Recommendation Report for Lawful Development Certificate for a Proposed Use or Development**REF NO:** A/186/24/CLP**LOCATION:** 1 Lansdowne Close
Angmering
BN16 4JN**PROPOSAL:** Lawful development certificate for a proposed extension and roof alterations to an existing craft-room / outhouse to create a habitable space.**DESCRIPTION OF APPLICATION**

Extension of an existing outbuilding to create a building measuring 3.7m wide by 7m deep and 4.6m high.

Proposed side elevation Plan:

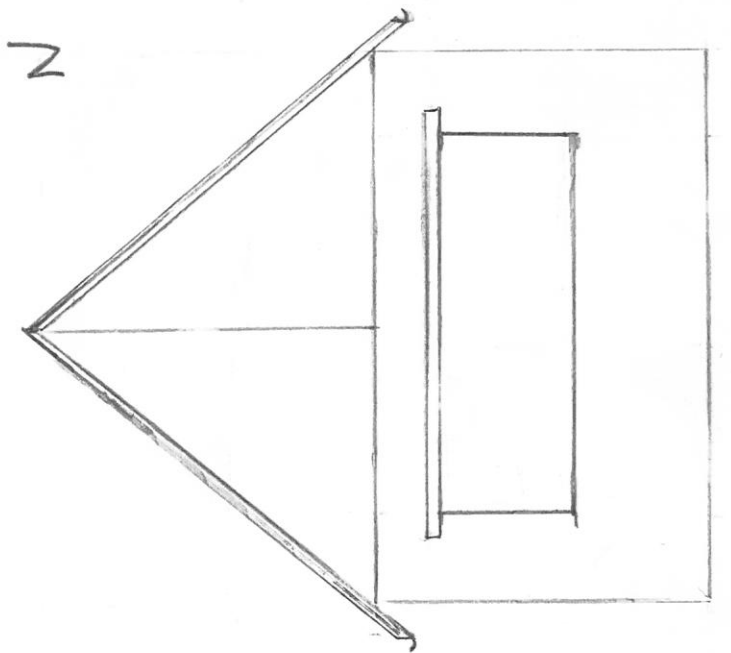
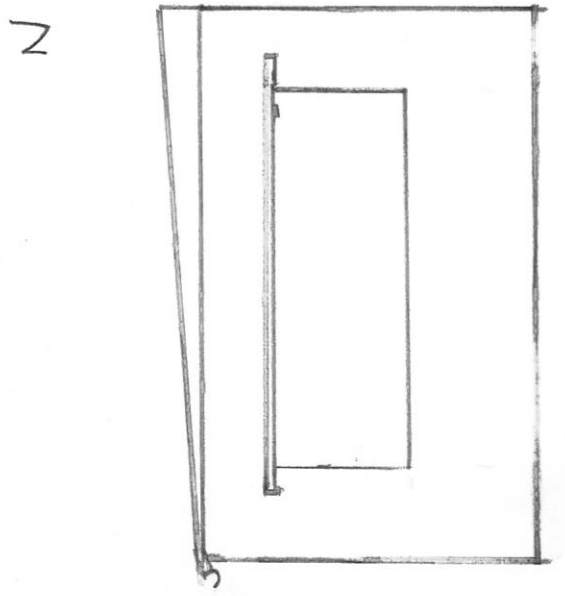
Section (e) of Part E requires that the height of an outbuilding with a dual pitch roof should not exceed 4m and that the maximum height of an outbuilding should not exceed 2.5m within 2m of any boundary. The proposed extension to the outbuilding exceeds these limits, having a total height of 4.6m. The outbuilding is also located adjacent to the boundary, thus the maximum height exceeds the 2.5m permitted height. The proposed building has accommodation in the roof space, and therefore has more than one storey, in conflict with section (d).

Proposed Floor plan for ground floor

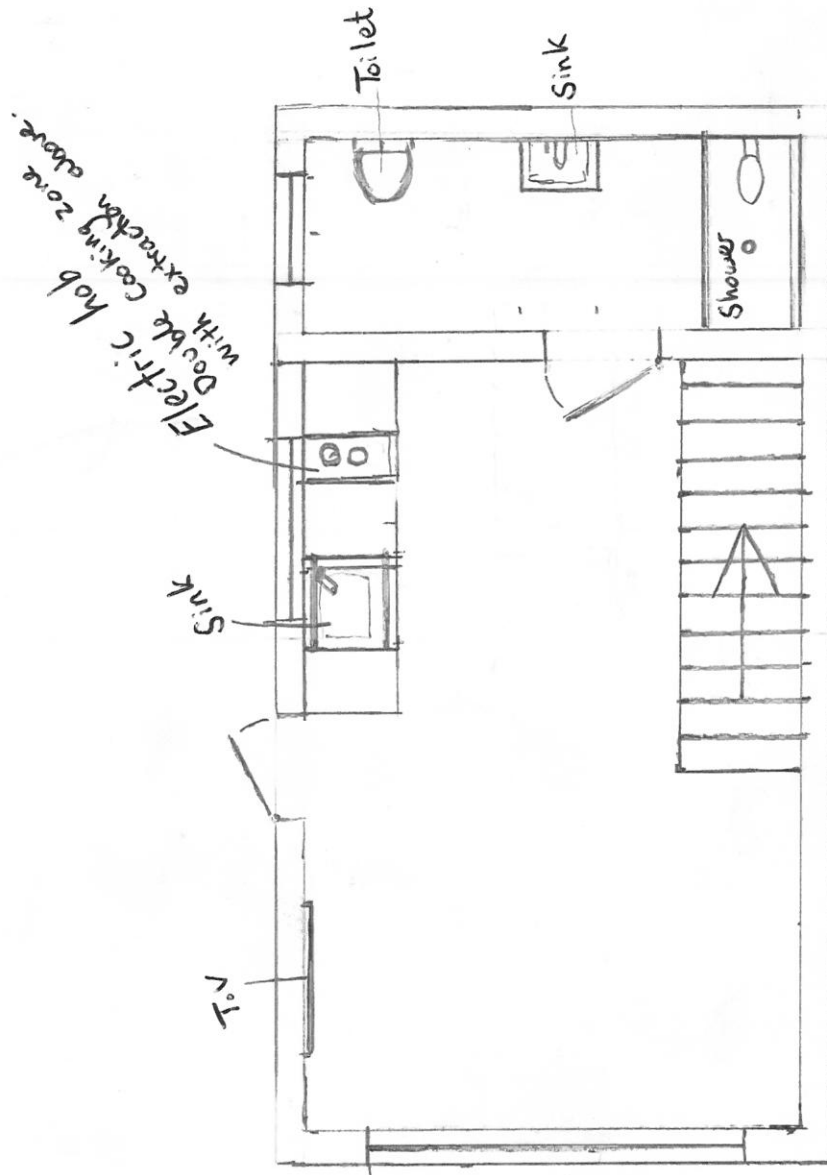
The proposed outbuilding contains a kitchen area, bathroom and bedroom. The outbuilding could therefore be used as a separate unit of accommodation, with no reliance on the main dwellinghouse. The technical guidance states that "a purpose incidental to a house would not, however, cover normal residential uses, such as separate self-contained accommodation or the use of an outbuilding for primary living accommodation such as a bedroom, bathroom, or kitchen". For this reason, the outbuilding is not considered incidental to the enjoyment of 1 Lansdowne Close. The proposed outbuilding therefore does not benefit from the provisions of this section of the General Permitted Development Order.
